**Re: Tierra Linda at 9801 Ceja Vista Rd. SW
Erosion and Sediment Control Plan (SWQ-2025-00036)
Engineer's Stamp Date 6/23/25 – P09E004**

Based on the information in your submittal received on 6/25/25, the ESC Plan and EPA Notice of Intent (NOI) can't be approved until the following comments are addressed.

OVERALL  
STORM DRAIN PLAN

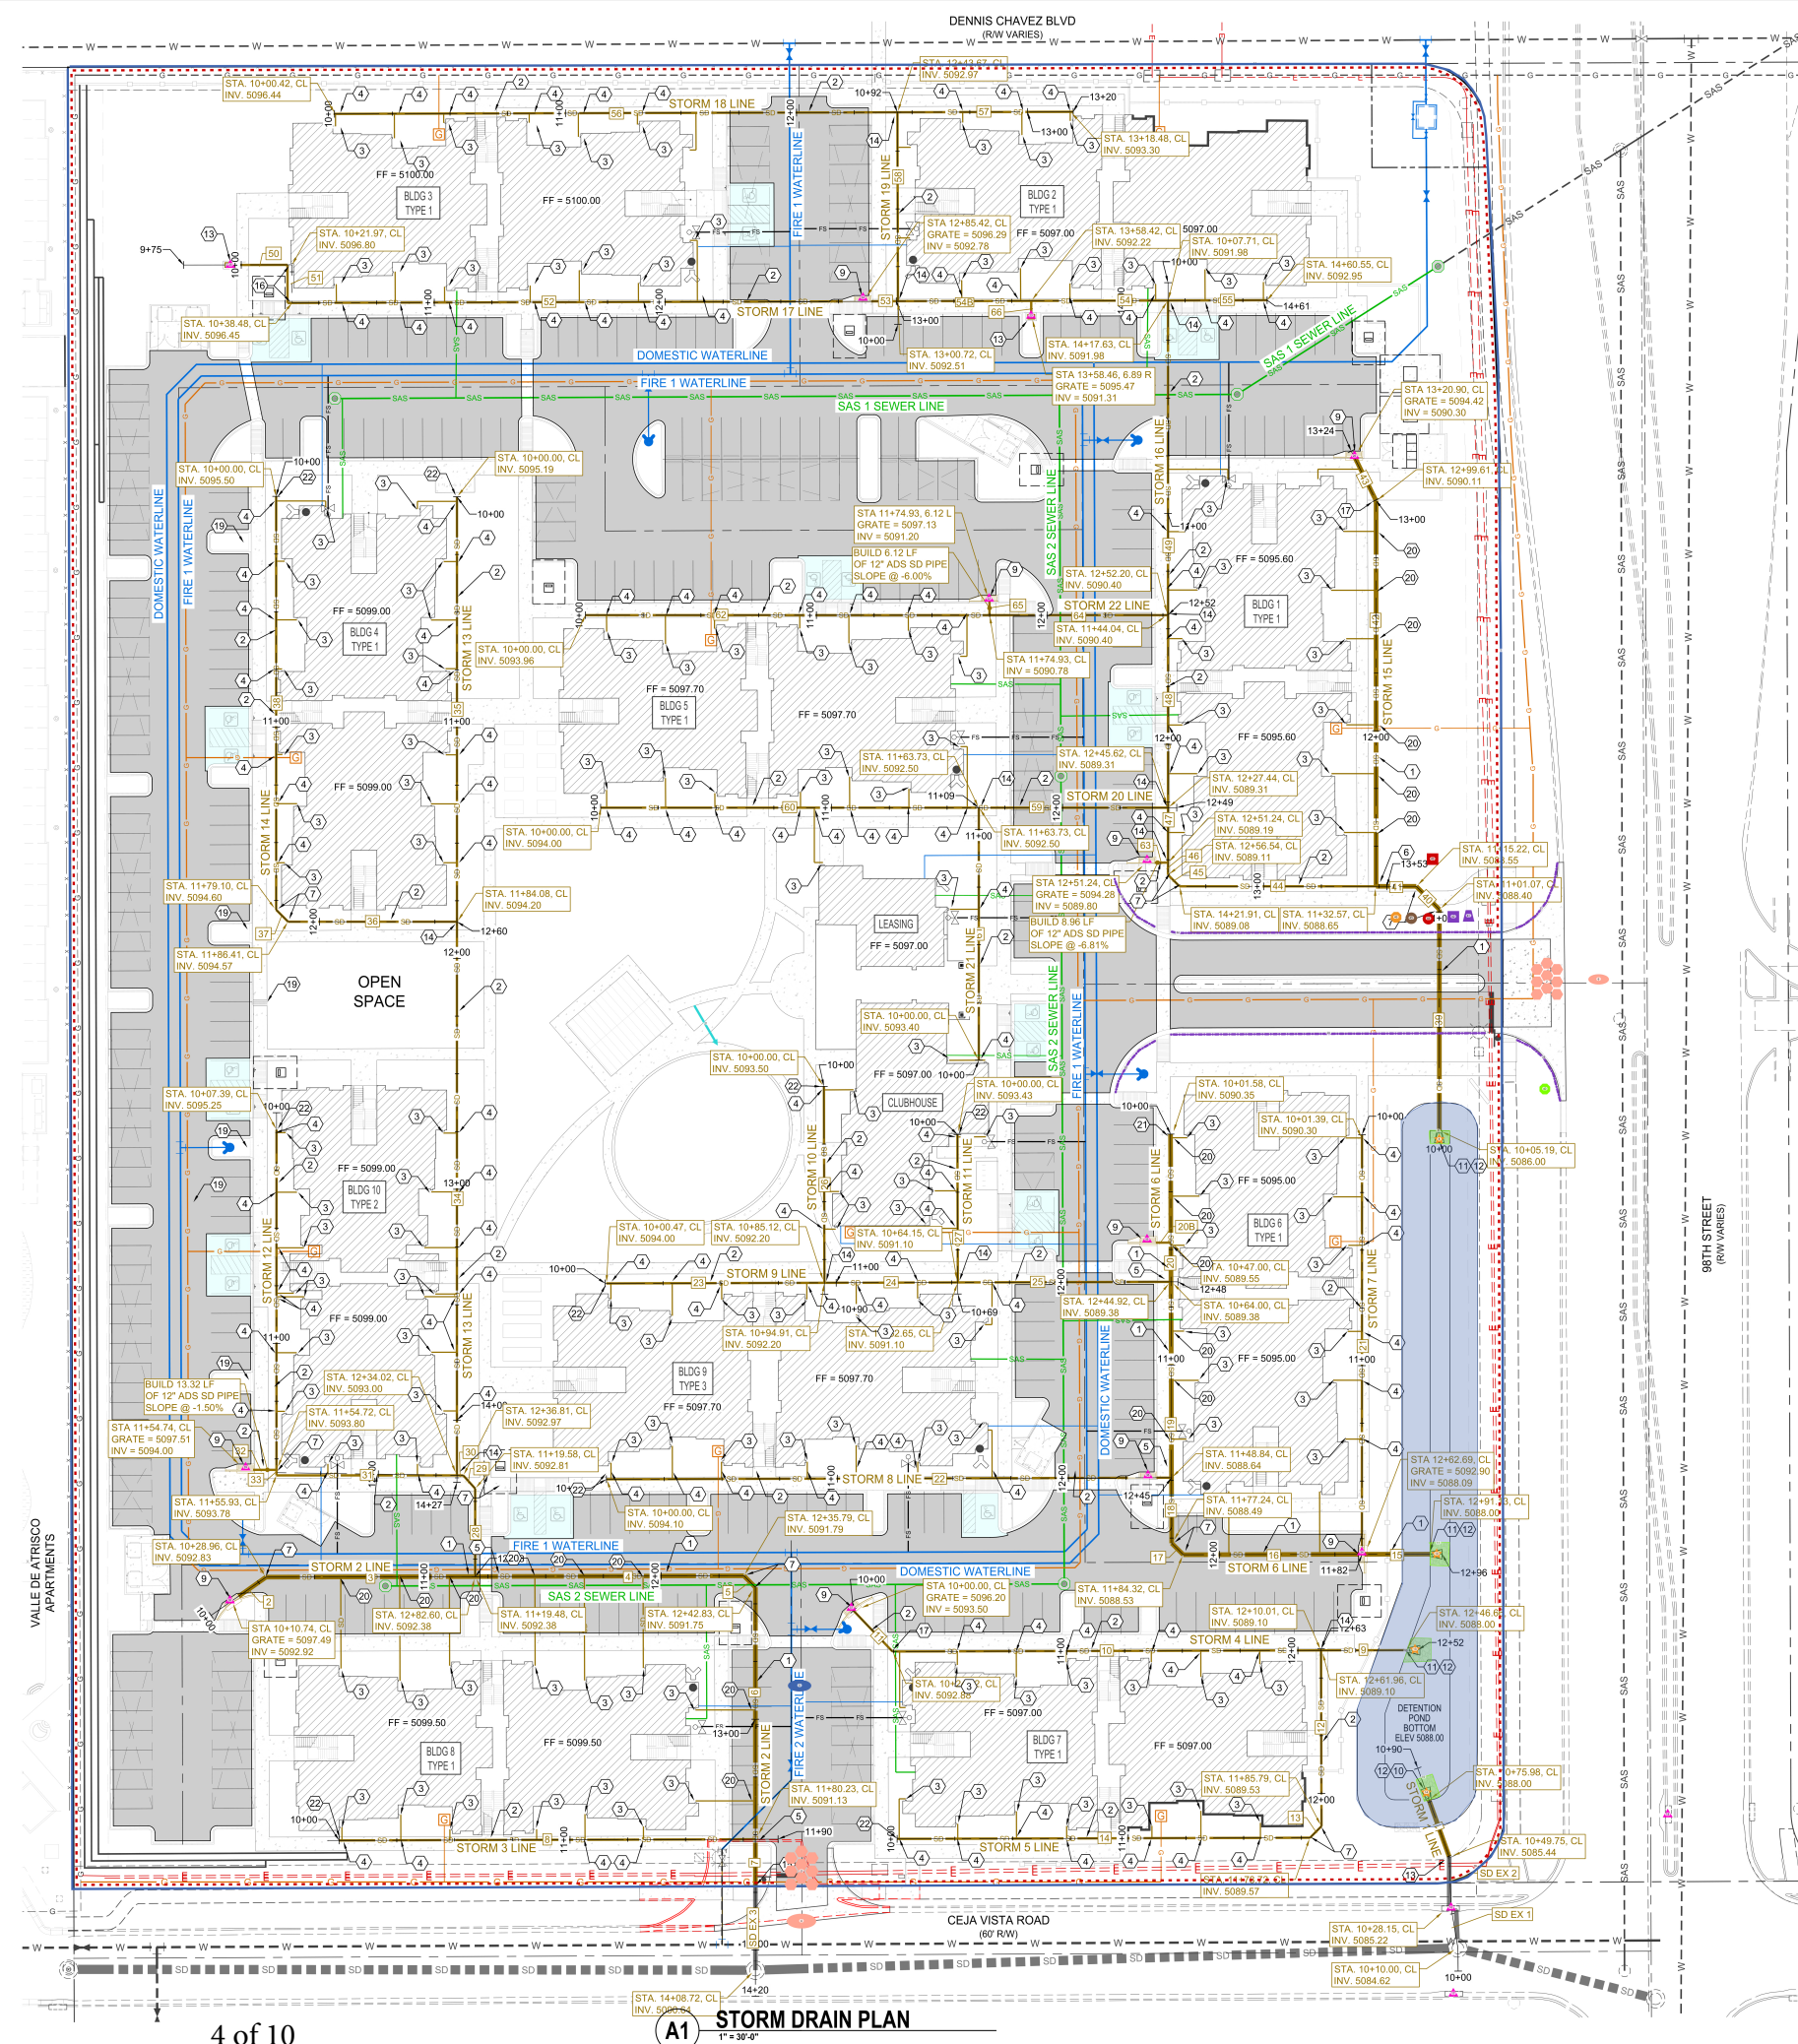
3. The property covers 11.2 acres, not 8.0 acres as shown on sheet 2 of the ESC Plan. An additional 0.3 acres will be disturbed by landscaping and other construction work in the nearby public right-of-way, bringing the overall disturbance area to 11.5 acres instead of the 8.0 acres listed on the NOI and sheet 2 of the ESC Plan. Both areas need to be updated accordingly.

5. Show on-site stormwater drainage patterns before and after major grading activities in accordance with CGP 7.2.4.f. Display existing and proposed contours and storm drains. They must match the approved G&D Plan.

6. Additional stormwater control Best Management Practices (BMPs) are required.
 - a. Silt fences are only effective stormwater controls when placed "on-contour". The silt fences shown on a longitudinal slope are inappropriate as stormwater controls. The silt fences on the north and south sides of the site may effectively control dust, but must be supplemented by temporary diversion berms.

- b. A temporary diversion berm or swale (DV) is needed in addition to the silt fence along the site's east perimeter. The silt fence alone does not effectively control the concentrated

stormwater runoff from the end of the parking lot at the northeast corner of the site. Silt fences are only effective when placed "on-contour" and for small areas (10,000 sq ft drainage area per 100 linear feet of silt fence). Either install another temporary sediment trap in the northeast corner or add a temporary berm or swale to divert drainage from the northern half of the site into the sediment trap in the southeast corner. Include a note on the ESC Plan stating that *"the DV must remain until the C&G and storm drain are built, effectively conveying the concentrated runoff into a temporary sediment trap."*

- c. Delete the east construction exit. Add a temporary berm or swale (DV) to divert flows from the driveway into a sediment trap, and put a note on the ESC Plan saying *"the DV is to remain in place until construction and stabilization are complete in the entire area drained."*

- d. Additional temporary sediment traps (STs) are needed at the sumps in the west parking lot to prevent stormwater runoff from being discharged from the site in the southwestern part of the onsite storm sewers. Add a note to the ESC Plan stating *"the STs are to remain in place until construction and stabilization are complete in the entire area drained."*

- e. Place notes on the ESC Plan near the two connections to the City's Storm Drain on Ceja Vista Rd., stating *"Storm drain connections to the City's existing pipes in Ceja Vista Rd. will not be allowed until construction and stabilization are complete in the areas they drain."*
